COMMUNITY DEVELOPMENT DEPARTMENT  
80 Columbia Avenue ♦ Marysville, WA 98270  
(360) 363-8100 ♦ (360) 651-5099 FAX

Re: Marysville Corporate Center – *Technical Review 1*  
PA 22004

RE: Marysville Corporate Center, File# PA22-004  
Binding Site Plan  
15908 47<sup>th</sup> Ave., Multiple Parcels

Project
MARYSVILLE CORPORATE CENTER
BINDING SITE PLAN (PHASE 1)

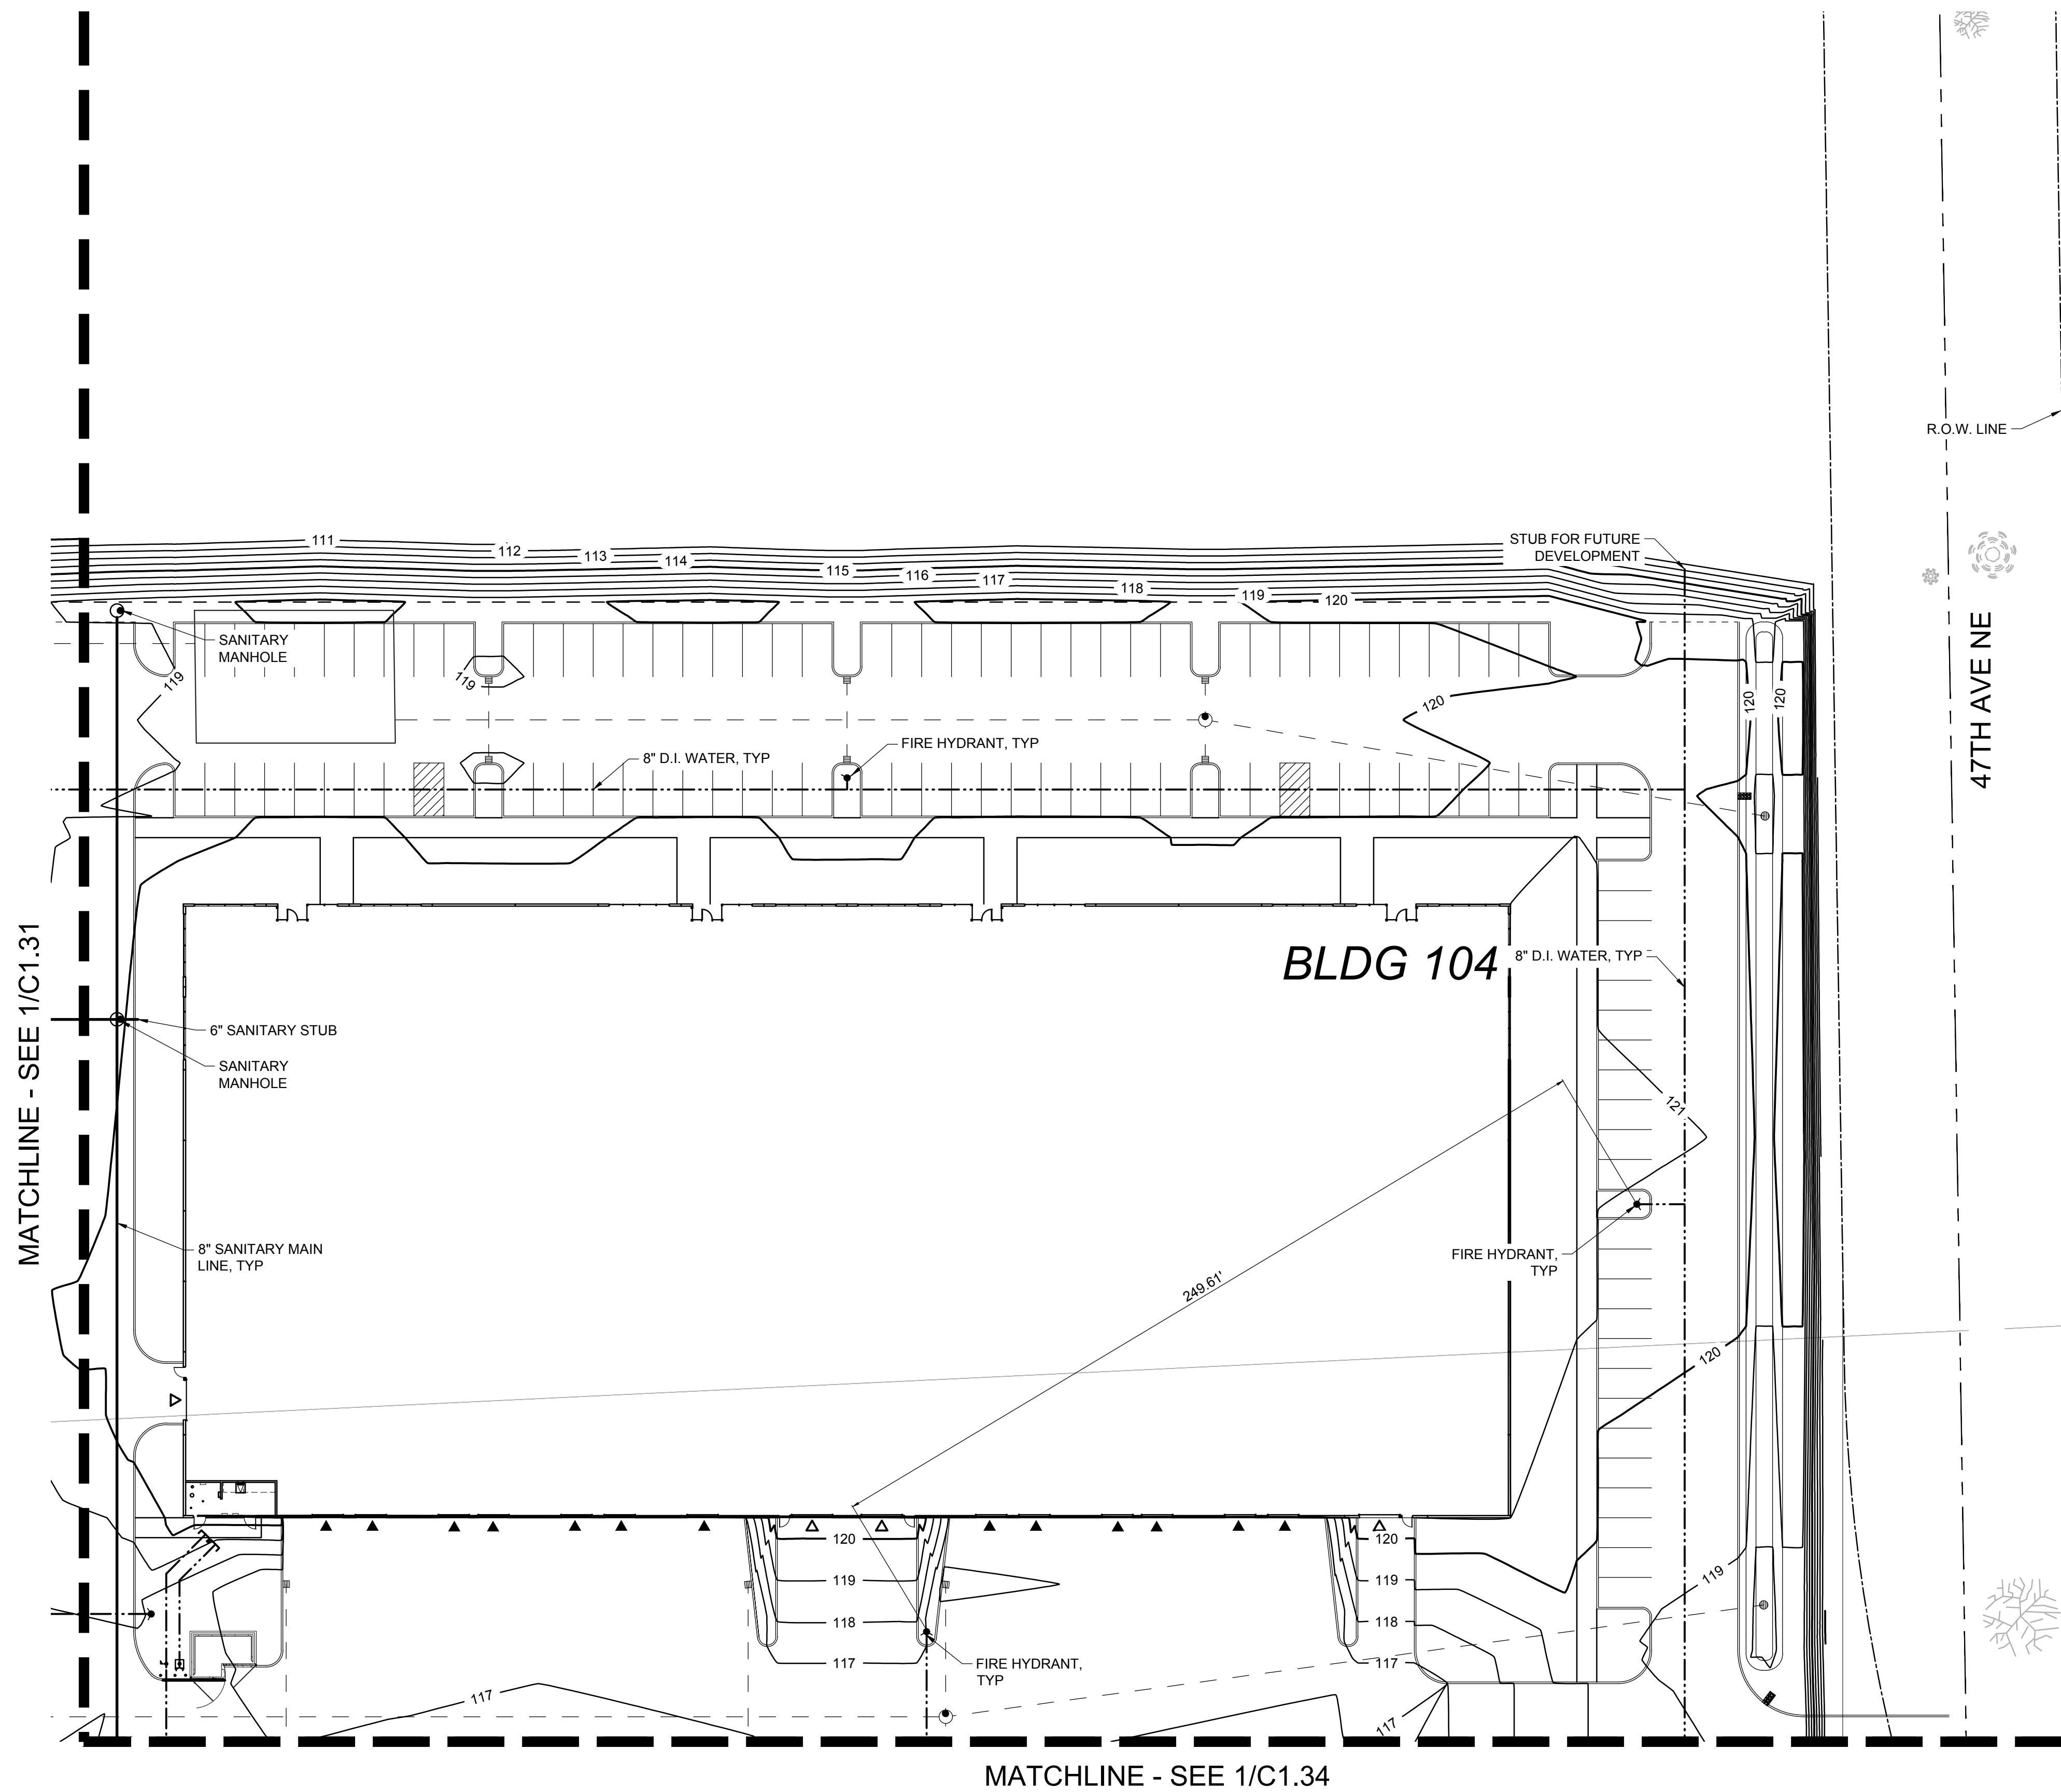
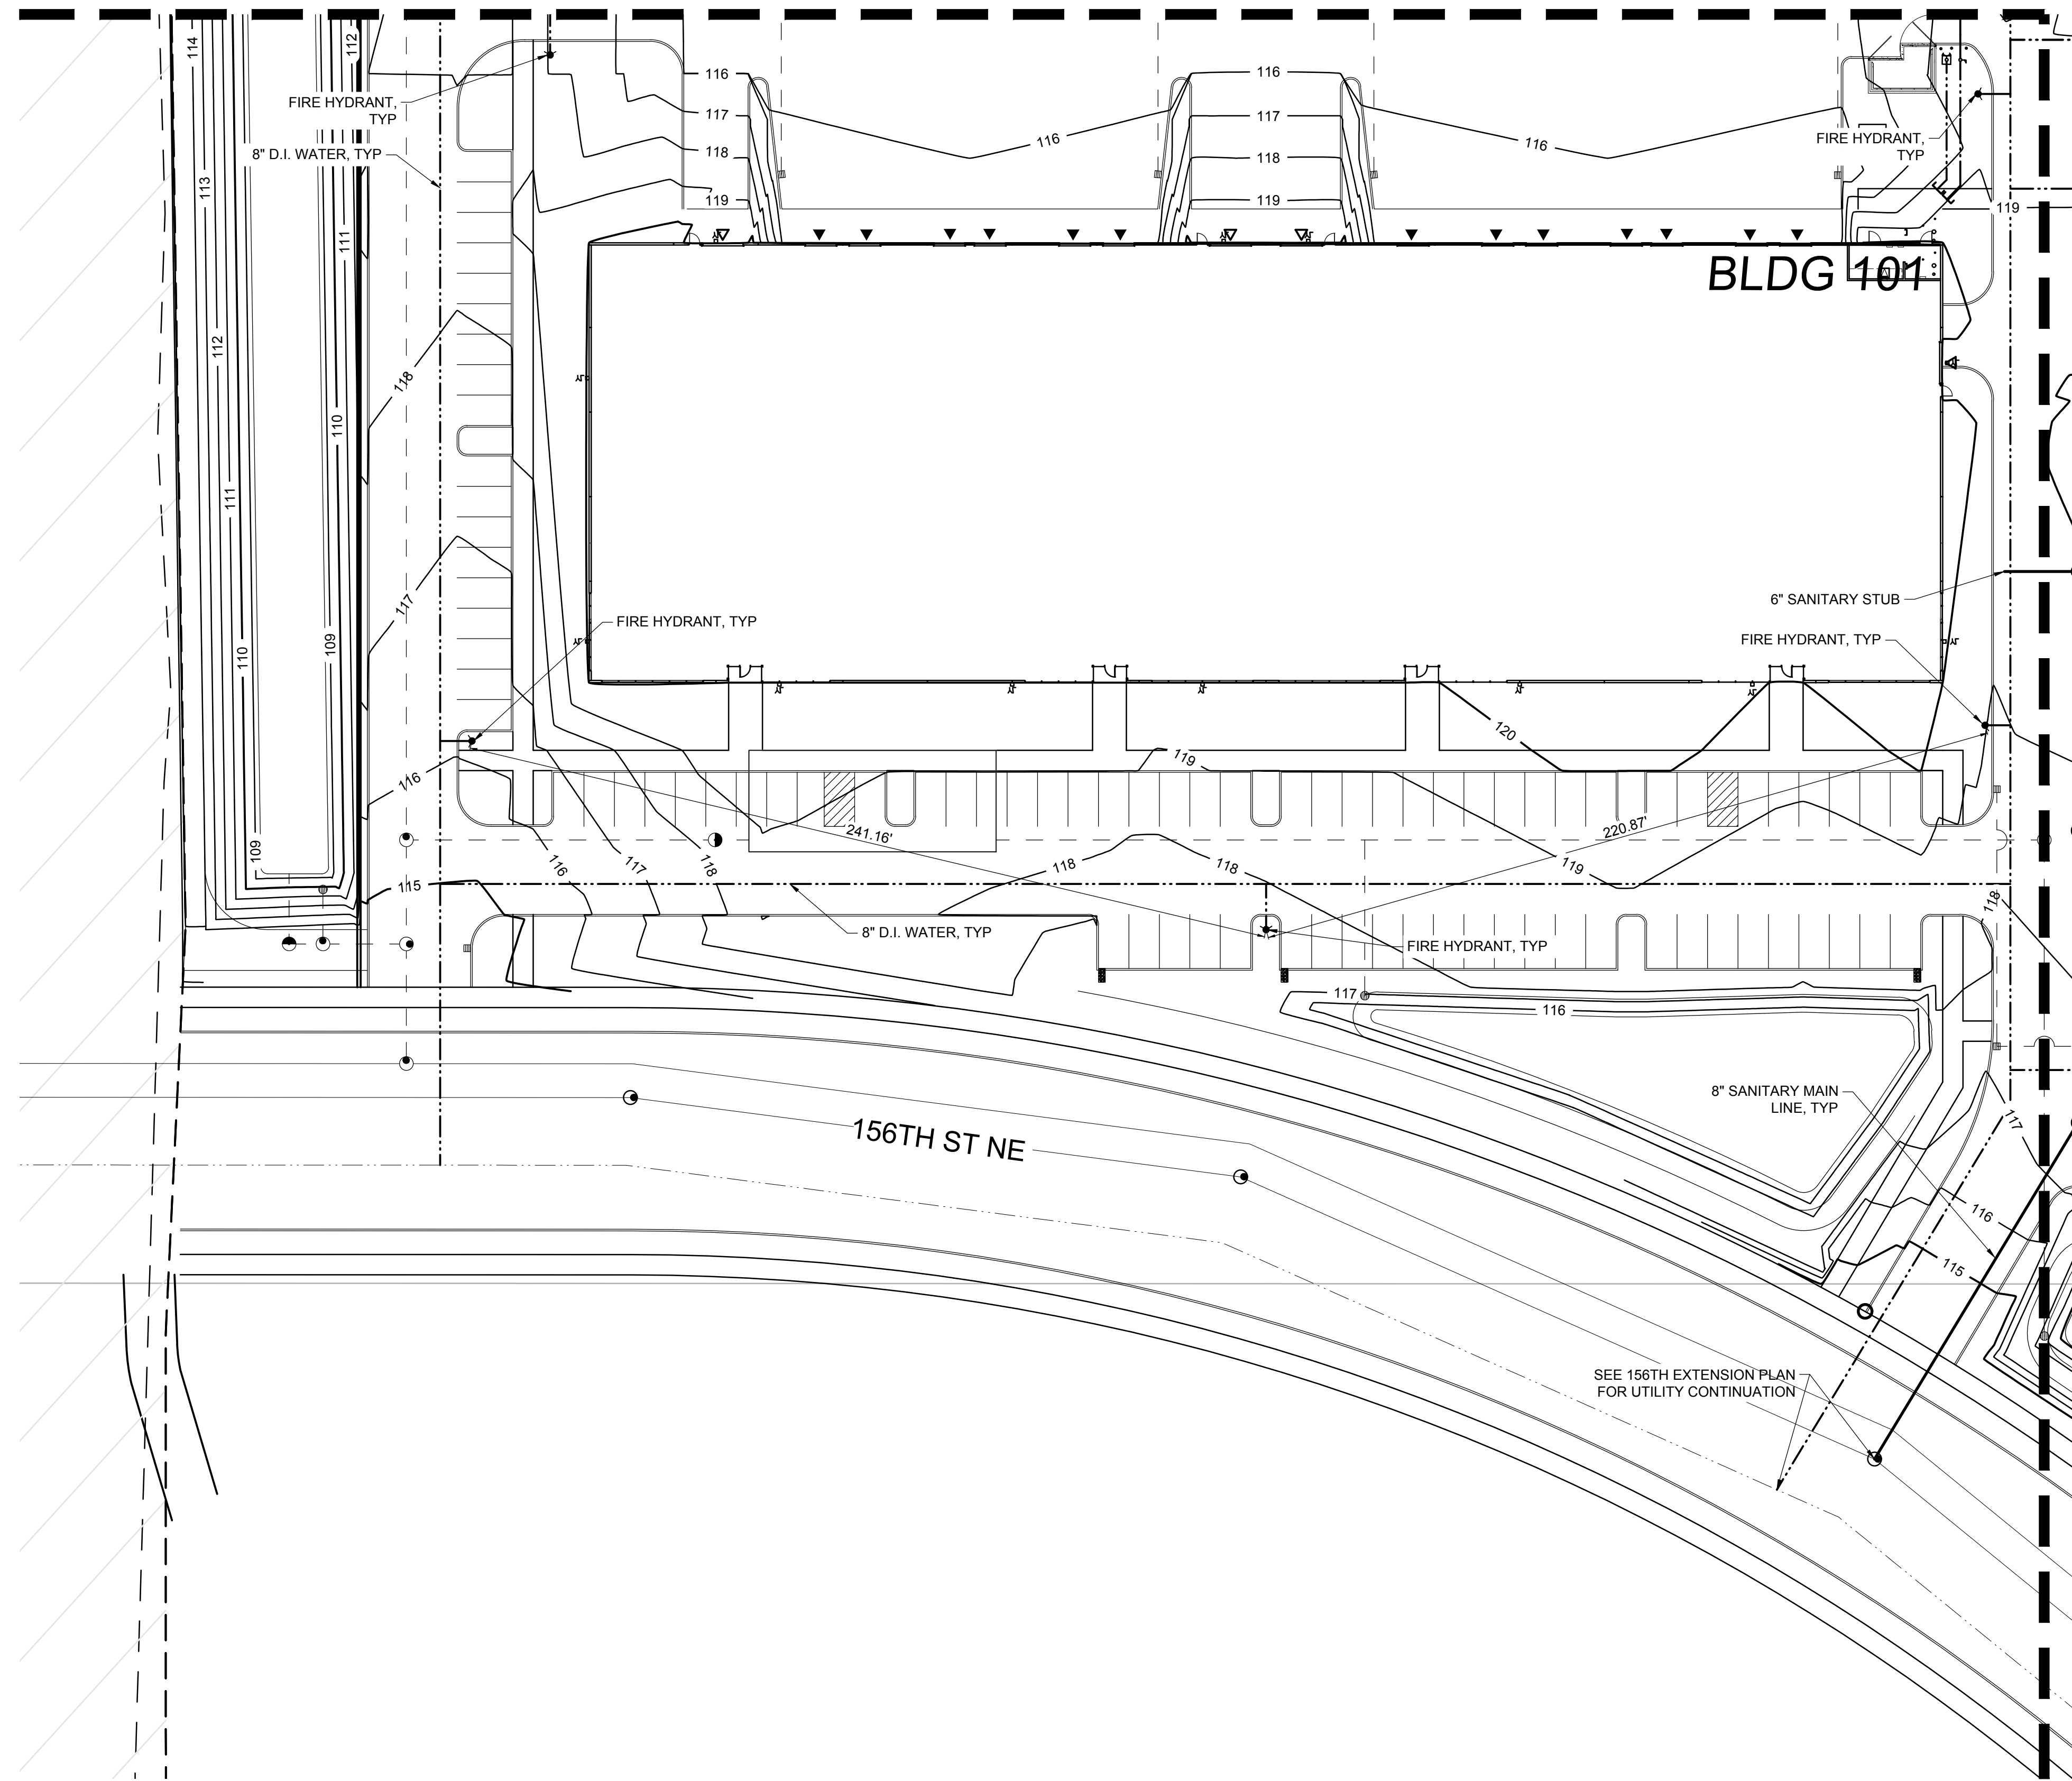
1. **Existing utilities:**
  - a. Sanitary sewer: The sewer manhole in 156th Street NE adjacent to the project is shown on RD325. The 18 inch trunk line, west of the project is shown on record drawing S619.

- b. Water: The waterline within 156th Street NE is available on RD325.
  - c. Storm: The storm drainage in 156th Street NE is also on RD325.
2. Per MMC 14.03.250, utilities are to be extended along the street frontages of the proposed project. Sanitary sewer and water mains shall be installed within the new City roads. Storm drainage facilities shall also be supplied for the new City roadways that are to be constructed.
